Subject: Rezoning Petition Review

Rezoning Petition #: 21-256

Location of Property: Approximately 150.78 acres located on the north side of Old Concord Rd, east of N Tryon St and south of W Rocky River Rd.

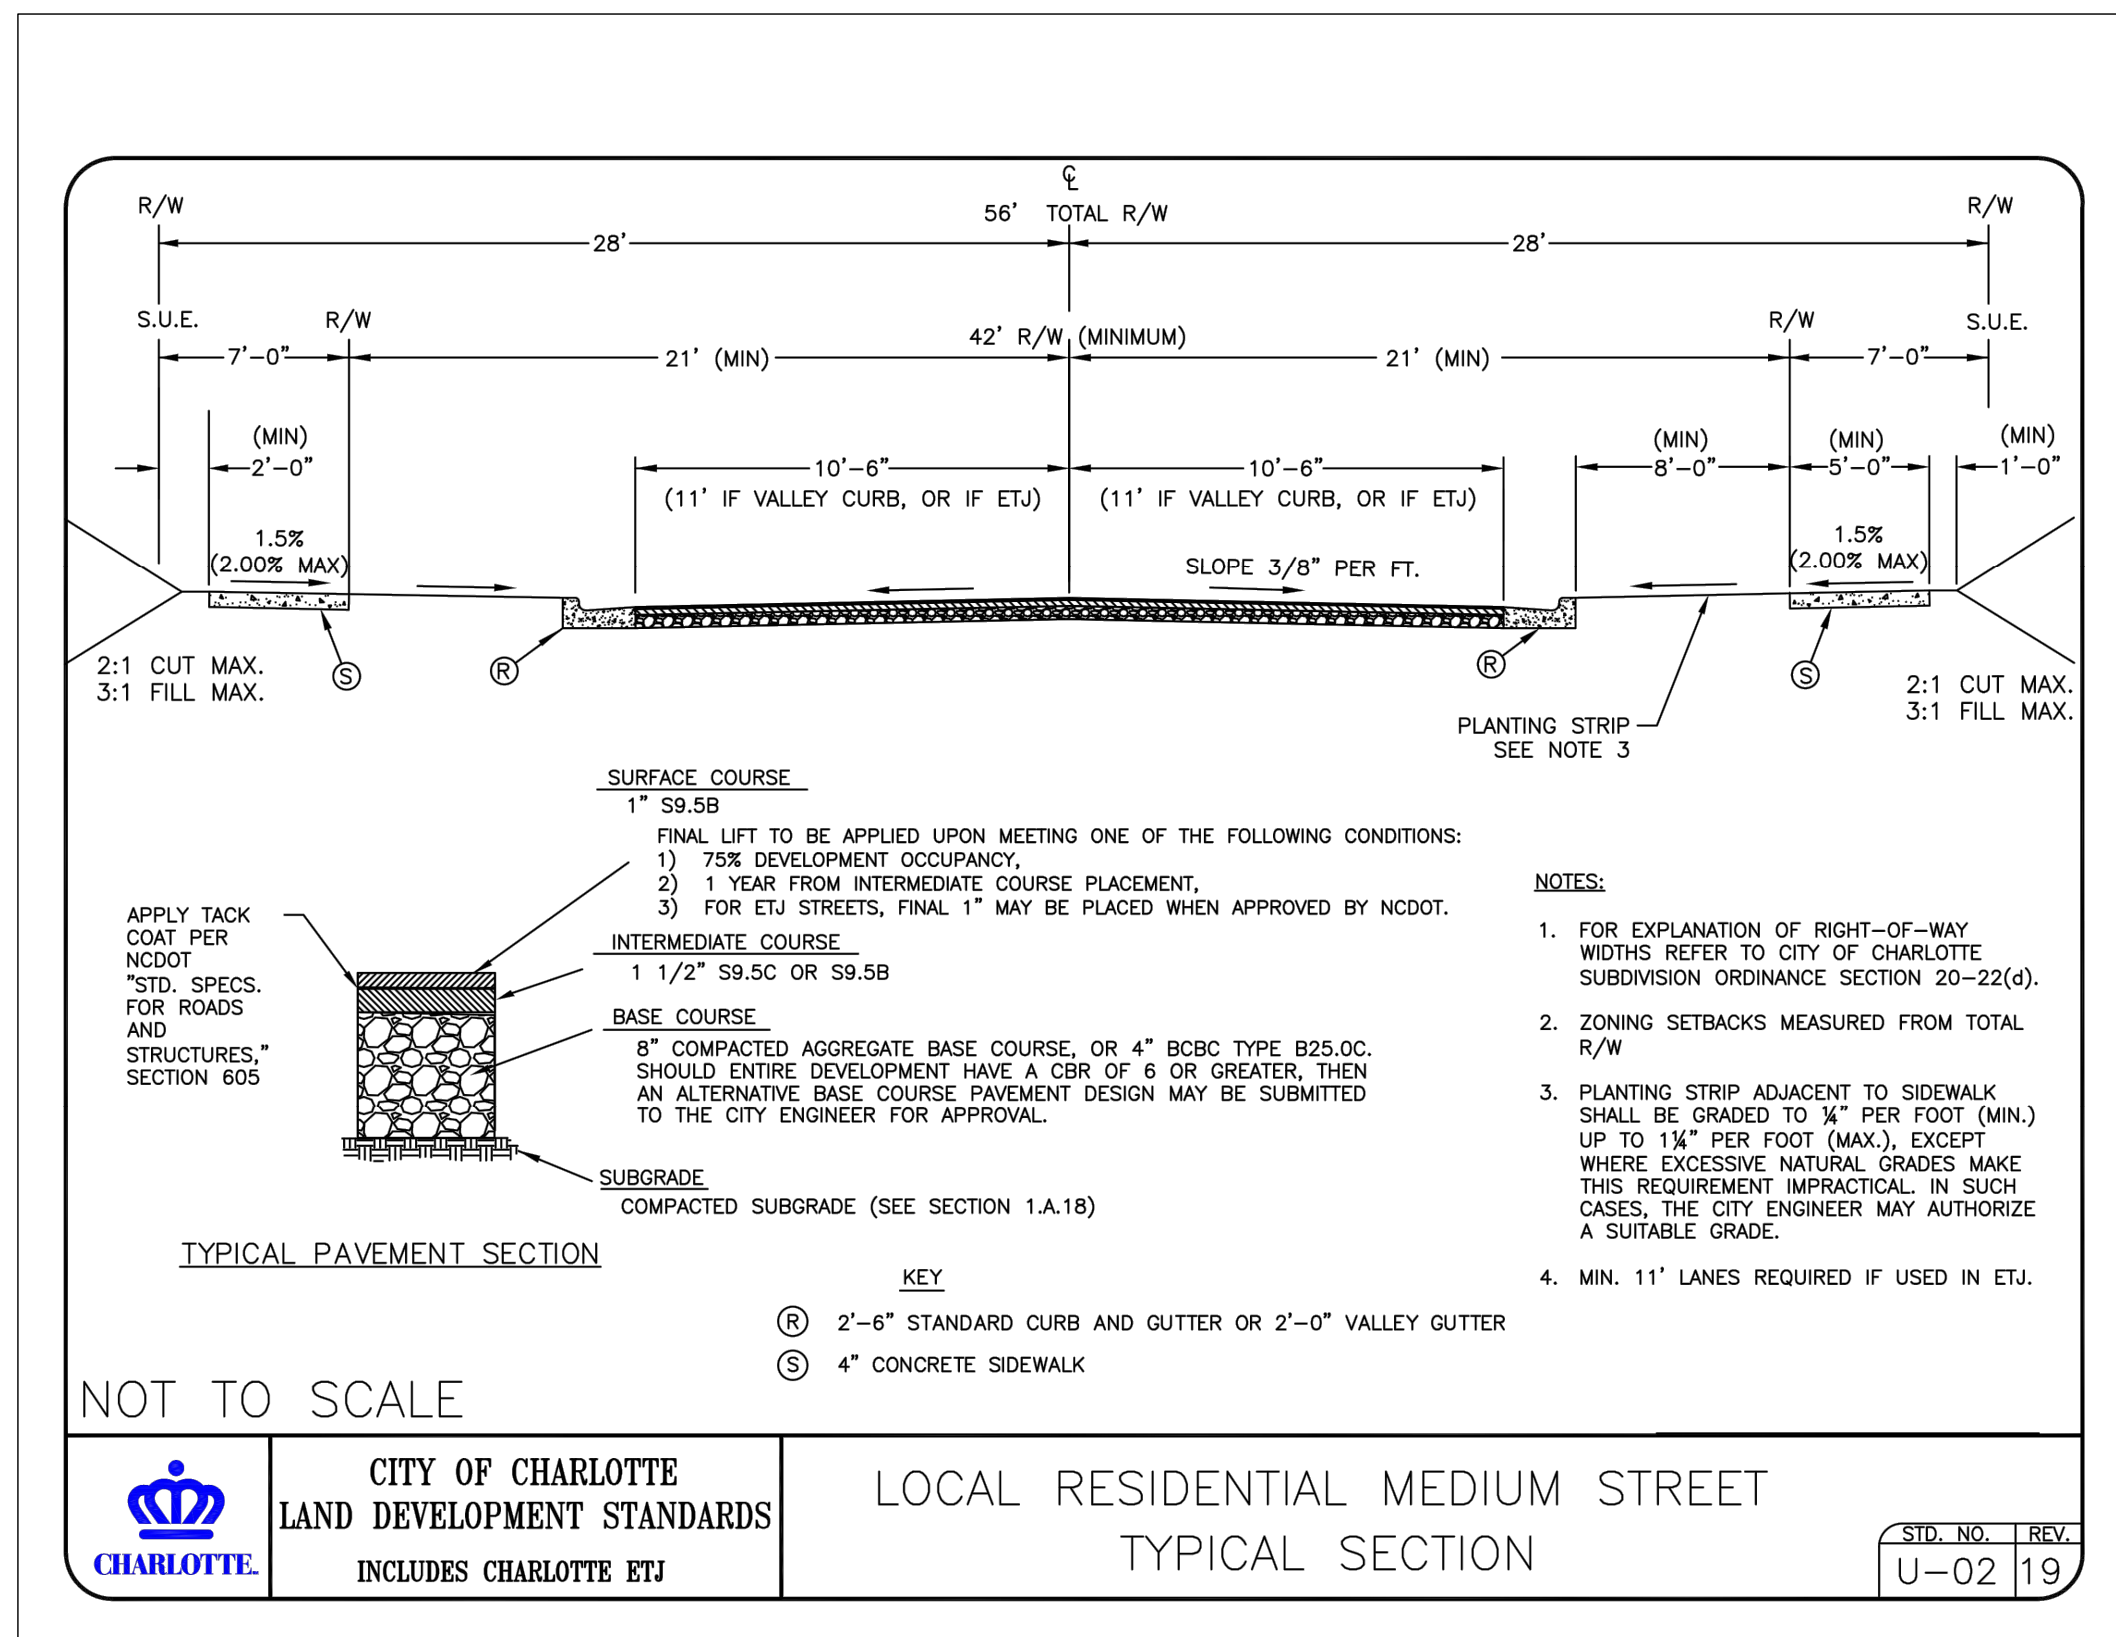
Please check and confirm PCSO Buffers on site. The site plan only shows 50-ft Buffers which should be 100-ft Undisturbed PCSO Buffers. City of Charlotte GIS also indicates a 50-ft Undisturbed PCSO Buffer approximately between the lower 2 SCMs on Development Area A.

Please show and label "*Potential 50-ft Undisturbed PCSO Buffer*" and "*Potential 100-ft Undisturbed PCSO Buffer*" on the site plan and include the following note under Environmental Features: "*Development within any SWIM/PCSO Buffer shall be coordinated with and subject to approval by Charlotte-Mecklenburg Storm Water Services and mitigated if required by City ordinance. Petitioner acknowledges intermittent/perennial stream delineation reports are subject to review and approval upon submission of development plans for permitting and are not approved with rezoning decisions.*"
